Ecology response

From: Jonathan Best <Jonathan.Best@arun.gov.uk>
Sent: 13 May 2025 16:46
To: Planning.Responses <Planning.Responses@arun.gov.uk>
Cc: Amber Willard <Amber.Willard@arun.gov.uk>
Subject: BR/67/25/PL

57 Queensway Bognor Regis PO21 1QN.

Drawing
Front Elevation

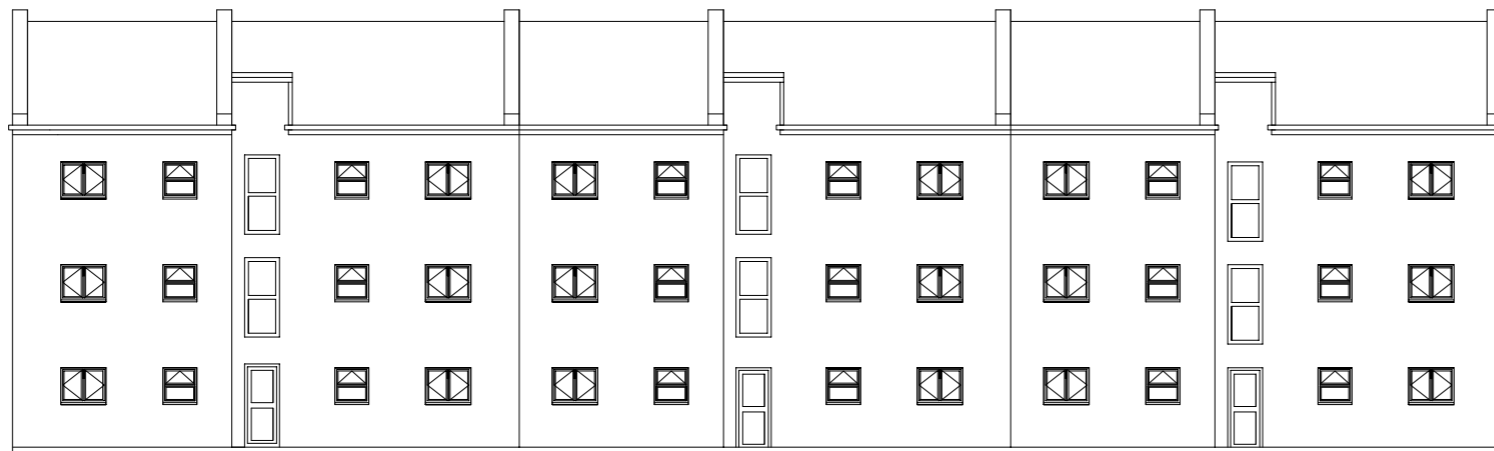
Installing integral swift bricks and integral bat bricks or tubes would be far better.

ECOBNG2 – to include 6 integral swift bricks on the front of the flats and 6 bat tubes or bricks on the rear of the flats and plans of soft landscaping and tree planting that benefits nature.
